2024/0481

43 Park Avenue, Penistone, Barnsley, S36 6DL

Single storey rear orangery extension to two-storey semi-detached dwelling

Existing and Proposed Elevations

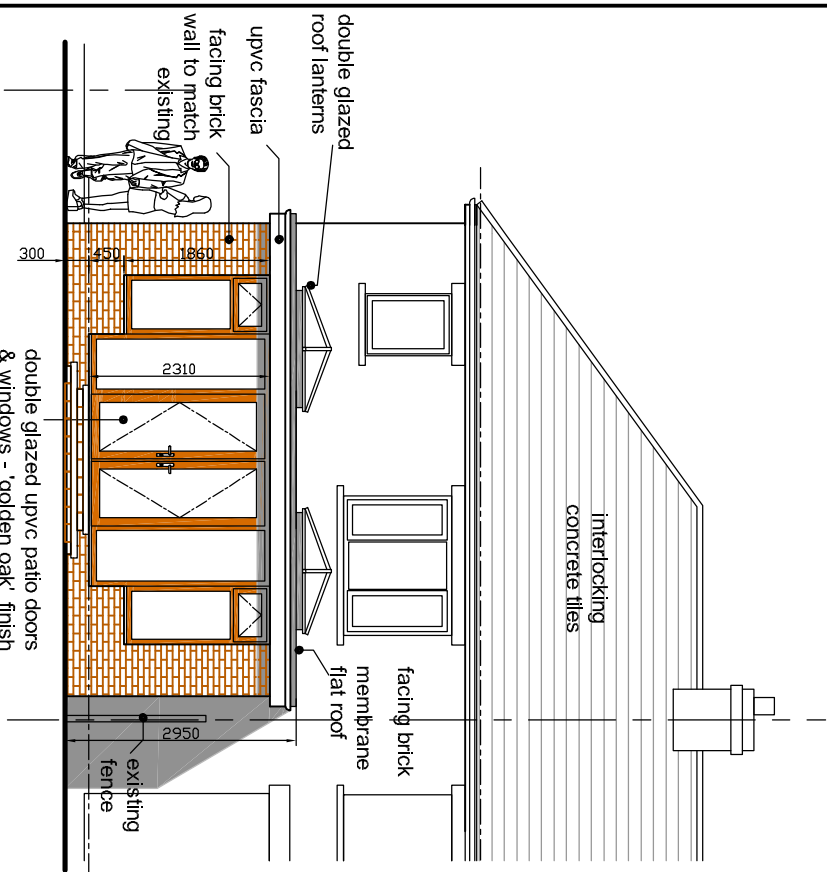
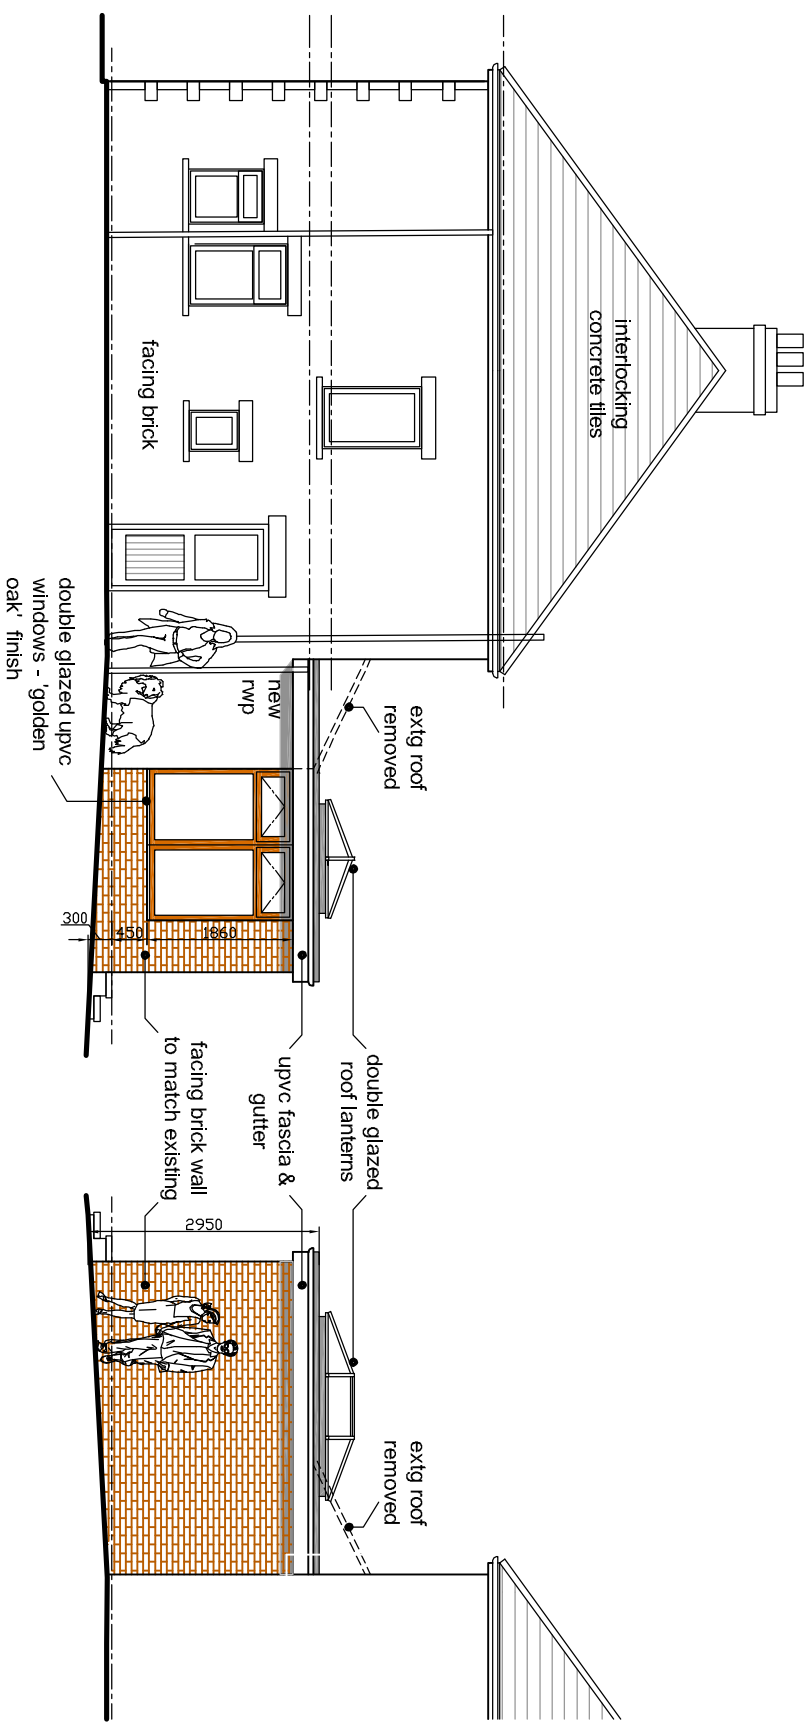
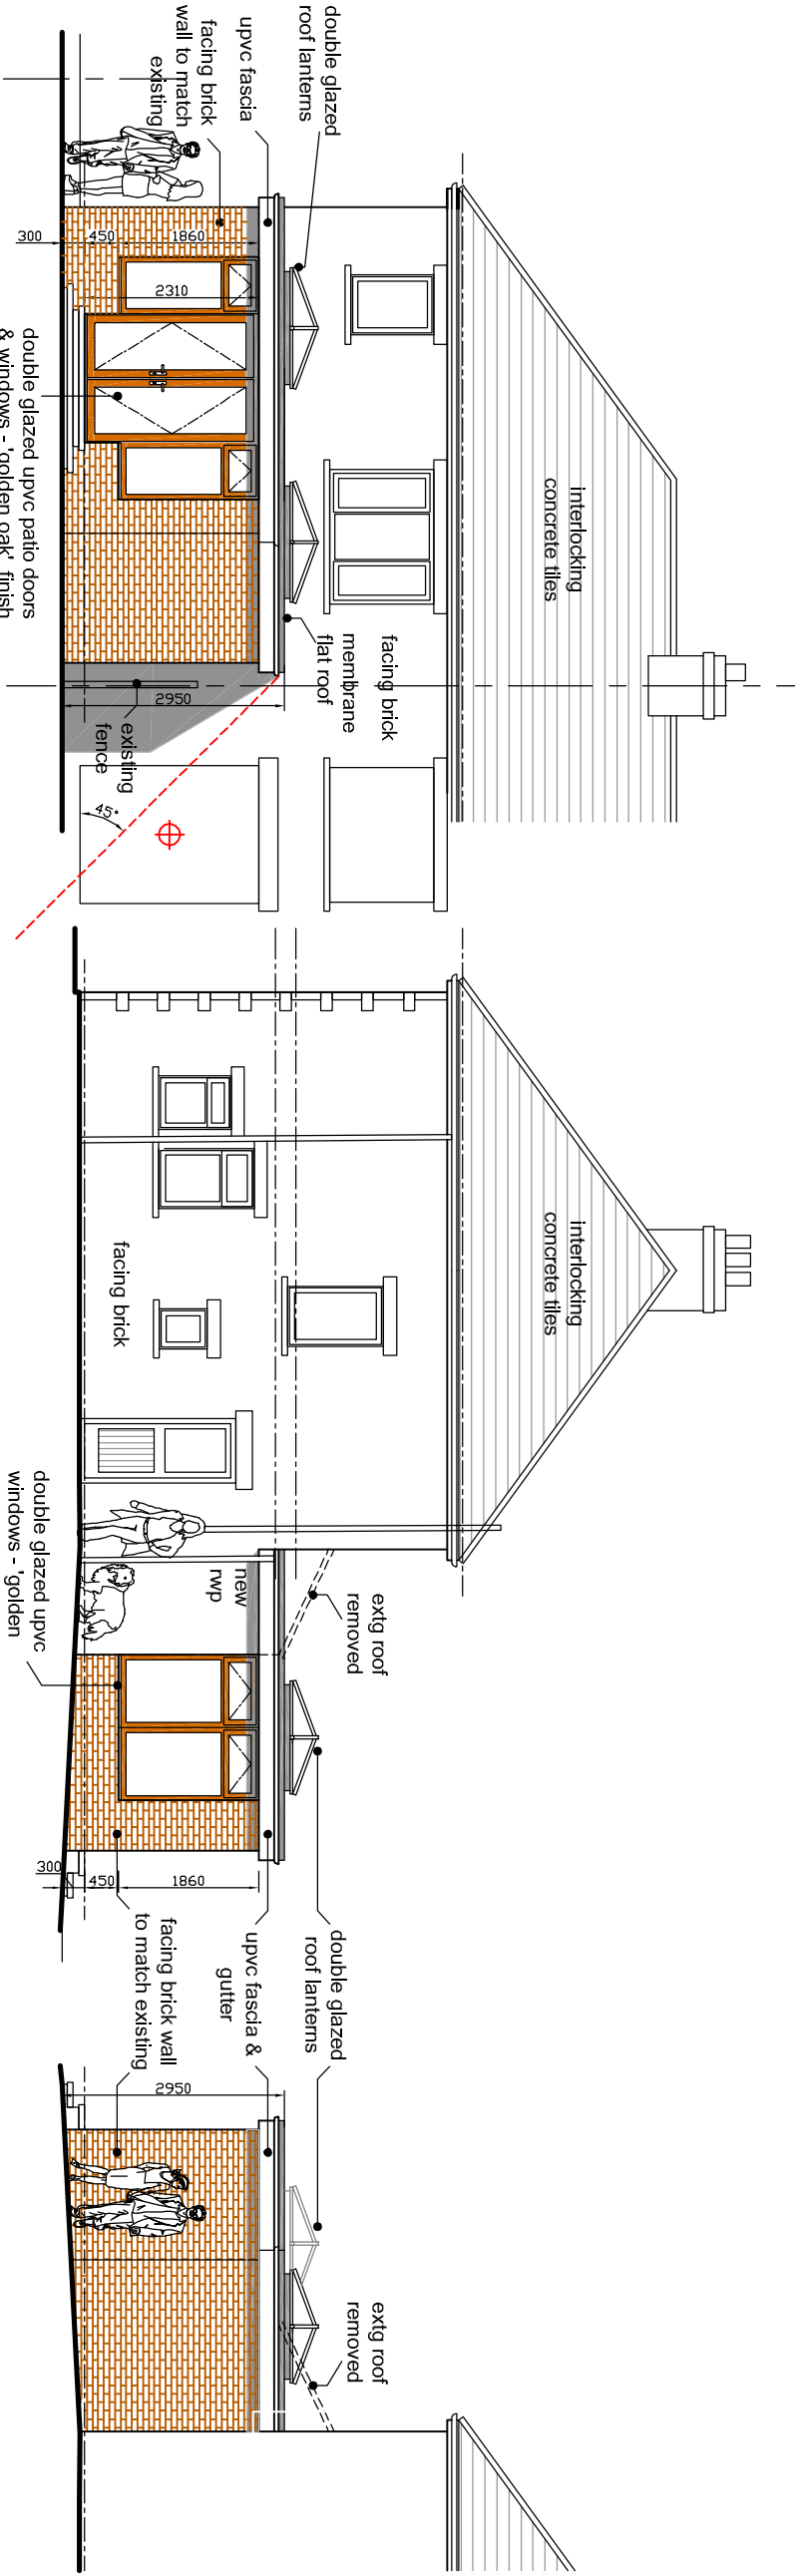
- The neighbour at No.41 Park Avenue will have the majority of light and view blocked at the rear of the property. Could the development adjacent to the boundary be taken further into the ground of No.43 to allow more light and view given the direction of the sun's movement means a significant loss of light to the rear of the property.

- This orangery will go 4 metres down the edge of my property. This will impact my property by blocking out my light and sun for almost the entire day, except an hour or two first thing in the morning. My garden and patio will become a sunless and dark area instead of the bright area it is now with the sun being in my garden most of the day.

The SPD states that *‘materials should normally be of the same type, colour and texture to the existing house or as close a match as possible’*. In this case, the proposed materials will match the existing dwelling with matching brickwork being used. The extension utilises a flat roof which is usually not a supported roof type due to flat roofs being an inferior form of construction. The flat roof is acceptable in this circumstance however, as it is set to the rear of the property and therefore not present in the street scene. This roof type also helps lower the roof height of the extension.

The proposed extension partially conforms to the SPD in terms of its external materials and roof type, however it will have little impact upon the character of the street scene due to the harmony with the existing dwelling and being set to the rear of the property. The proposed development is therefore not considered to be contrary to Local Plan Policy D1: High Quality Design and Place Making and is considered acceptable in terms of visual amenity.

The applicant is seeking approval for the erection of a single storey rear extension. The extension will project 4 metres from the rear elevation of the dwelling and has since been amended to reduce the projection to 2.3 metres adjacent the adjoining dwelling. The extension has a width of 6.05 metres. The extension will feature a flat roof with a total height of 3.3 metres and an eaves height of 2.4 metres. The materials used will be matching brickwork.
